DECISION DELEGATED TO HEAD OF PLANNING

Application No: H18-1242-25 **Applicant:** Sis Pitches

Proposal: Construction of new MUGA playzone for football basketball and netball with associated fencing and lighting

Location: Sutton Bridge Memorial Park Sutton Bridge Spalding

DRAWING TITLE:
Tree Protection Plan.

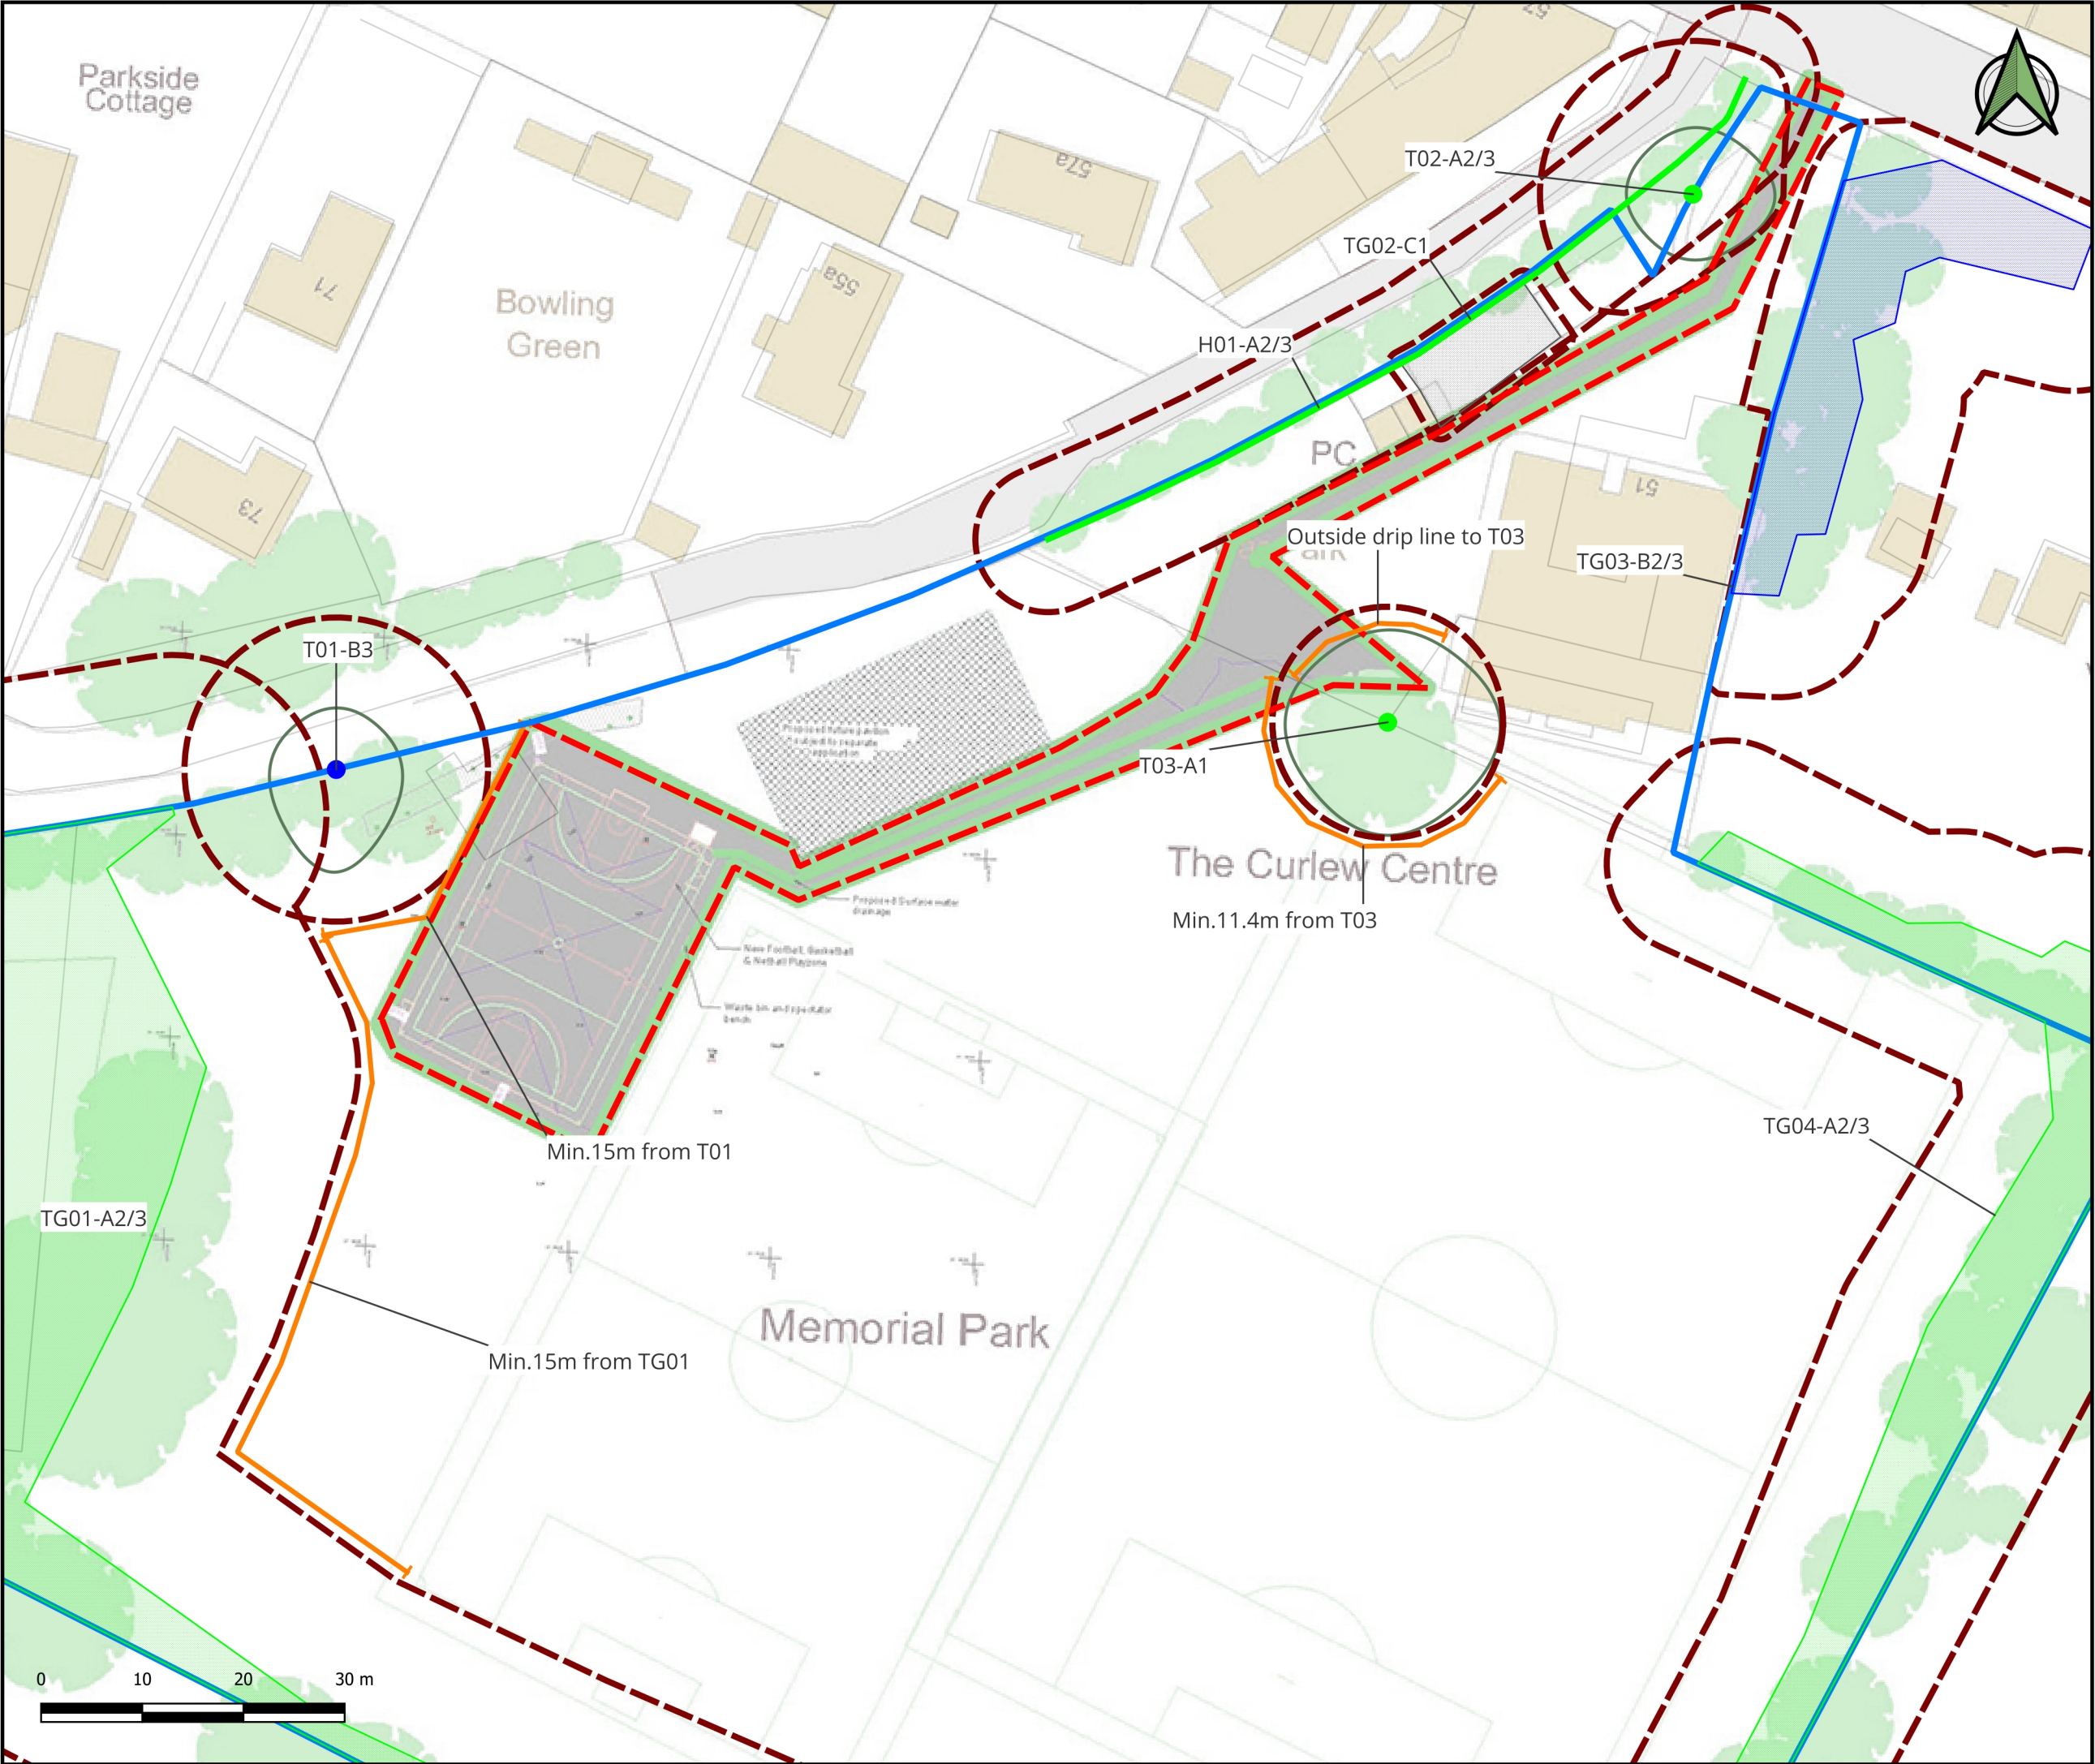
The current proposal shows a drain run to be constructed within the Root Protection Area of the tree. This will cause extensive root damage, which when combined with the effect of the tarmac over the roots, could be seriously detrimental to the wellbeing of the tree. The drain run(s) should be diverted so as not to cross the roots of the tree.

It is likely that the tree may benefit from access to a limited amount of extra water, such as a soakaway outside of the actual Root Protection Area, as oaks are high water demand trees

Subject to the imposition of an appropriate condition securing a revised drainage strategy that avoids harm to the protected oak tree, the proposal is considered to comply with Policy 4 of the South East Lincolnshire Local Plan.
